Town & Country Planning Act 1990 (as amended)
Town and Country Planning (Development Management Procedure) (England) Order 2015
Approval of details reserved by condition imposed under ref APP/C3810/W/17/3170059 (Y/80/16/OUT)
relating to Condition No 11 - maintenance & management of sustainable drainage scheme.
Land to the south of Ford Lane East of North End Road Ford BN18 0DS

Arun District Council have decided to **REFUSE details reserved by condition for the following reasons:**

The information submitted regarding Condition 11 imposed on the outline planning permission Y/80/16/OUT: relating to details of the implementation, maintenance and management of a sustainable drainage scheme is refused and the condition is hereby not discharged.

Redrow Construction Phase Plan

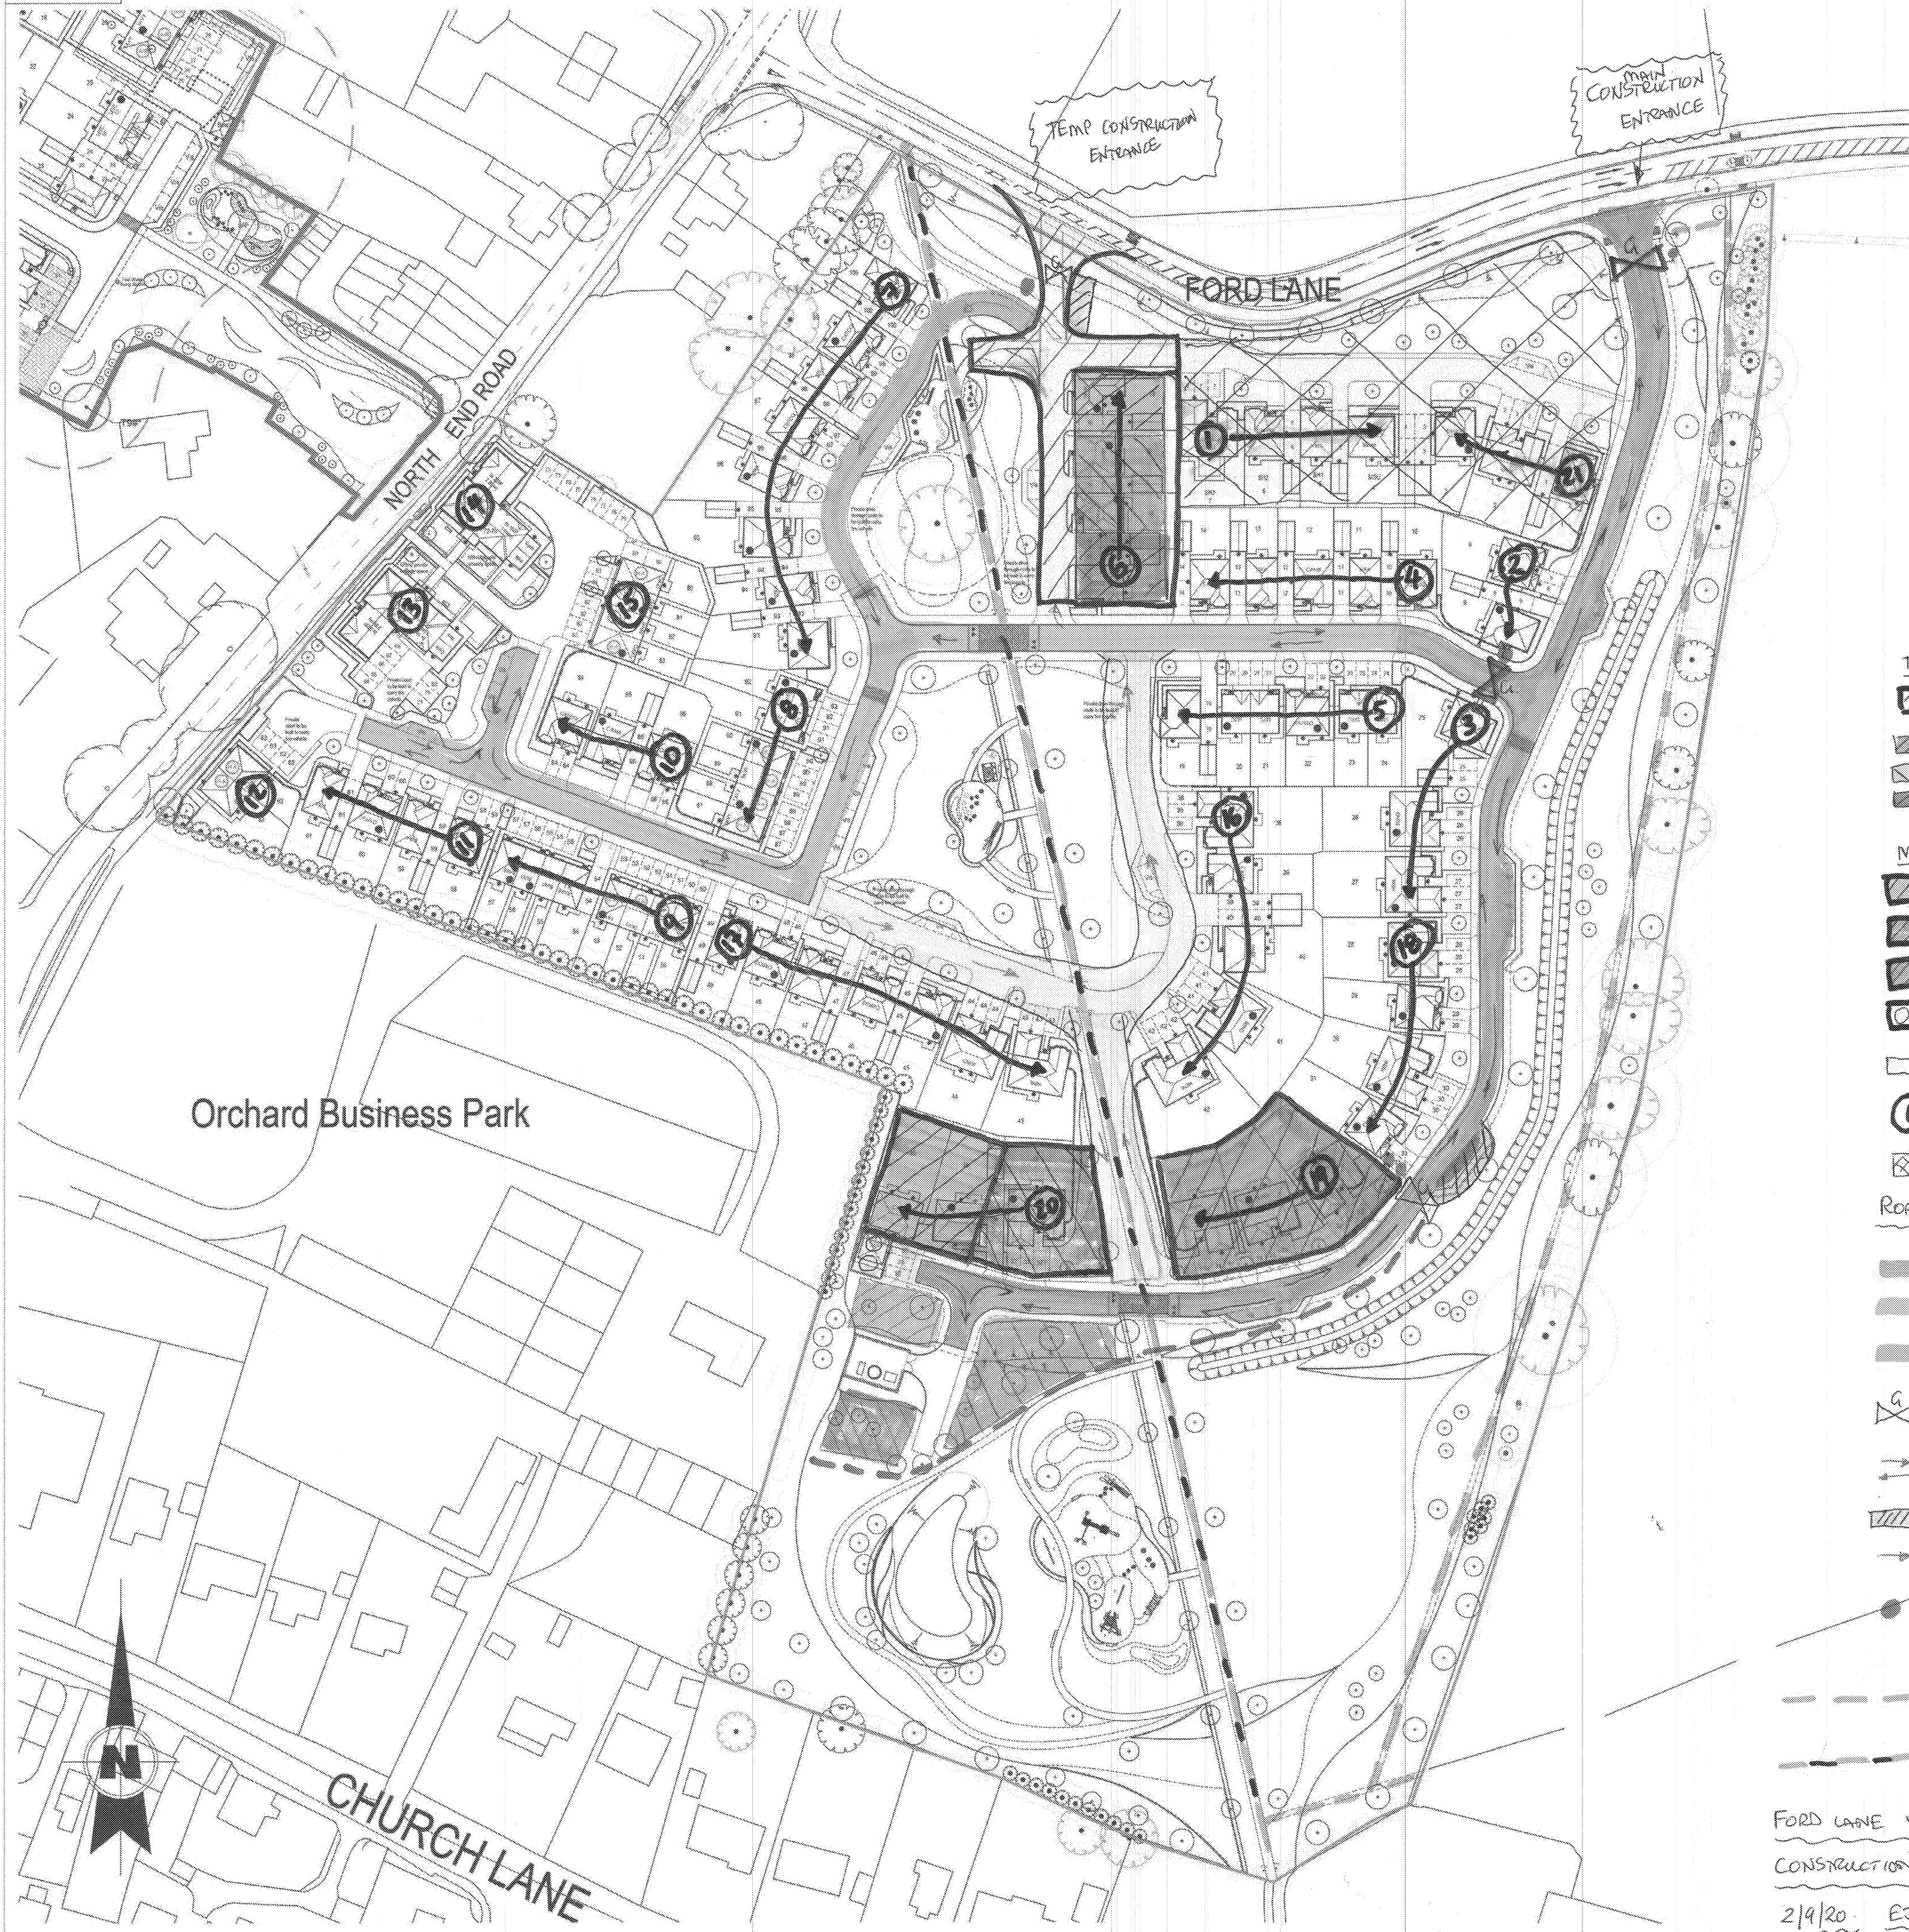
5. Details on the timescales for implementation are very poor. The order of construction including drainage has not been clearly defined. It must be very clear how it will be ensured that the drainage elements serving each phase of development will be constructed and completed prior to occupation of these phases.
